From: Neil Crowther  
Sent: 29 April 2014 16:12  
To: [REDACTED]  
Cc: [REDACTED]  
Subject: LU/51/14

I also said at the meeting that I would provide some comments on the proposals in terms of design even though the proposed layout plan is indicative. These are included below;

DESIGN PROPOSALS - LAYOUT

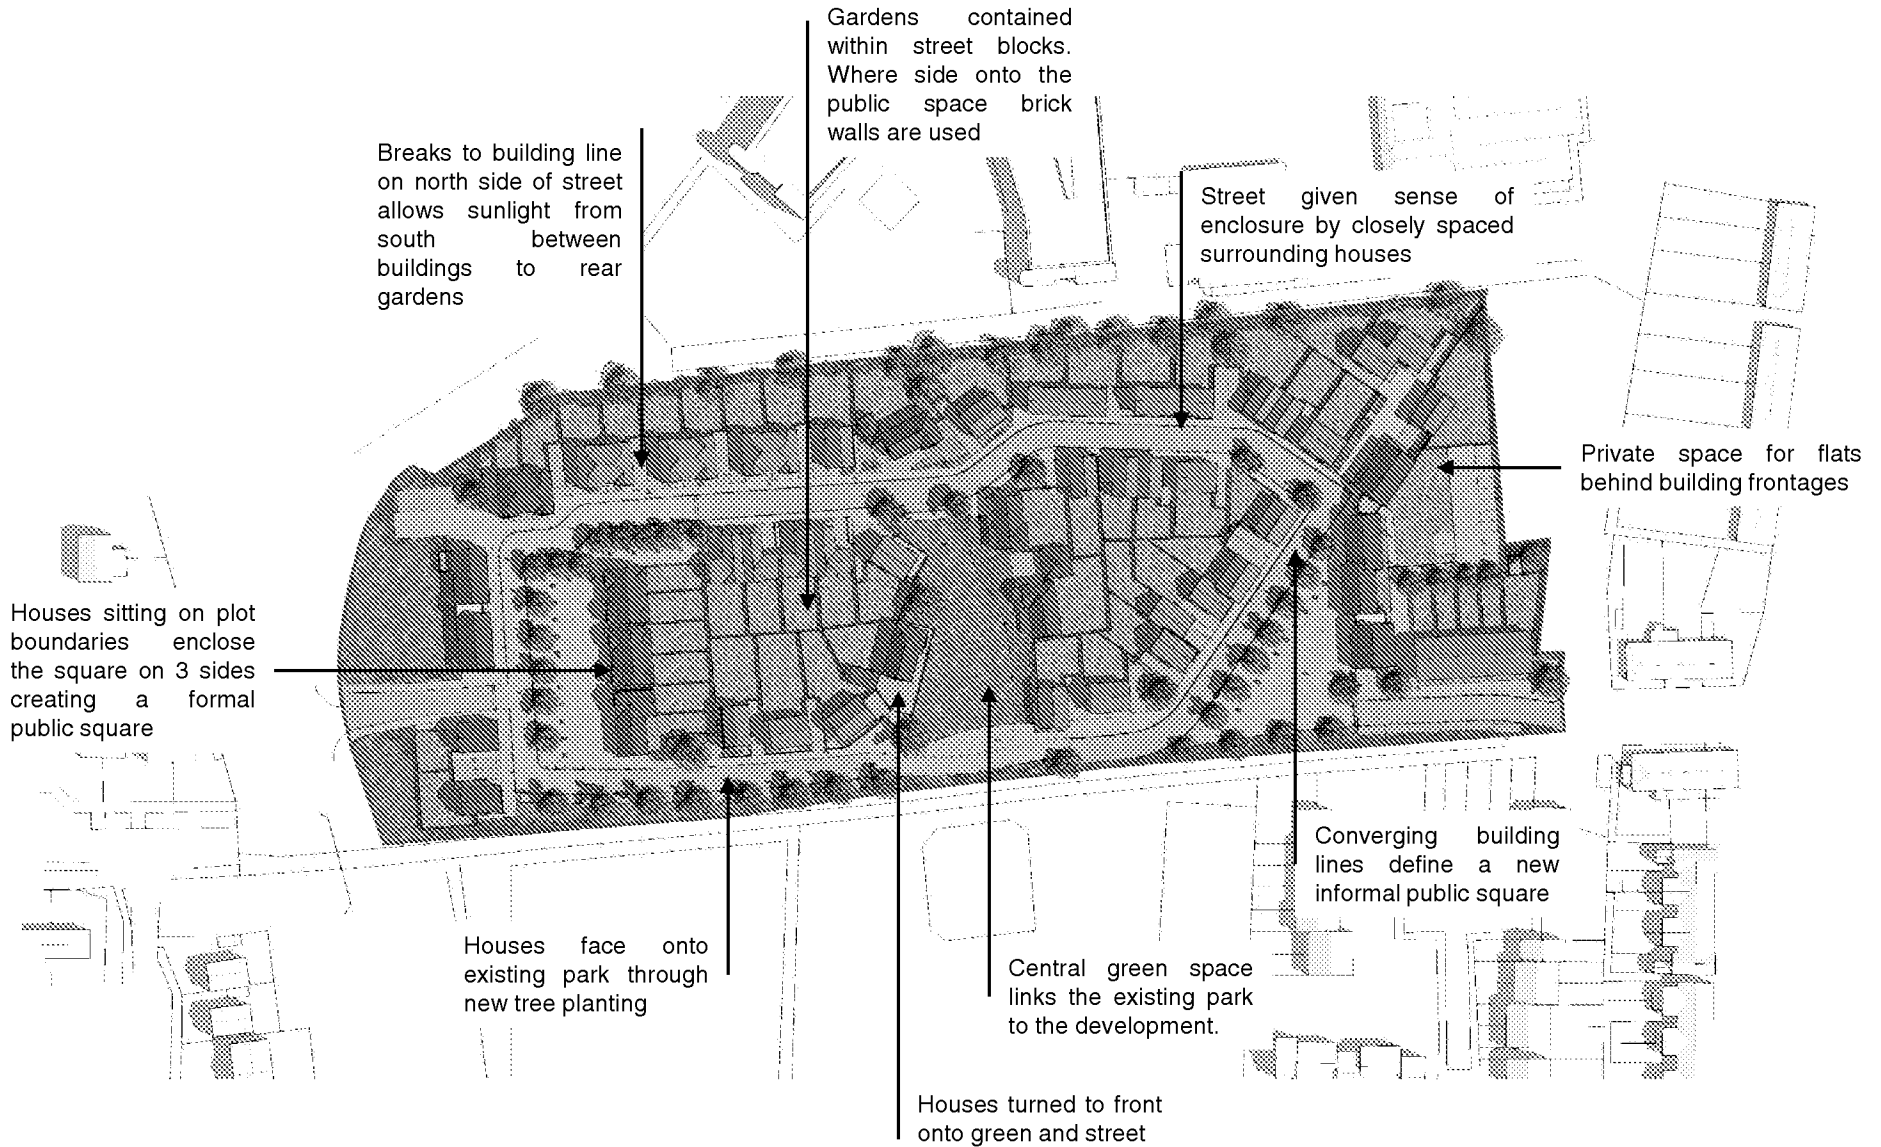
- The internal and external space standards are contained within the emerging local plan at policies DDM2 and DDM3. These require a minimum of 10m depth rear gardens.
- The proposals must 'front' onto Fitzalan Road. The illustrative layout shows units with back gardens onto this route and this would result in a refusal of planning permission.
- The scheme would require approximately 3,900 sqm of open space (on the basis of an indicative mix at this stage). Normally, this would also include a requirement for a 400sqm Locally Equipped Area of Play. The indicative layout includes only approx. 1,000 sqm of open space and this is also shown as a potential storage basin. This is obviously inadequate but we would also not accept a storage basin as open space.
- The paved areas would not contribute towards open space as these would be considered as amenity areas as part of the design approach.
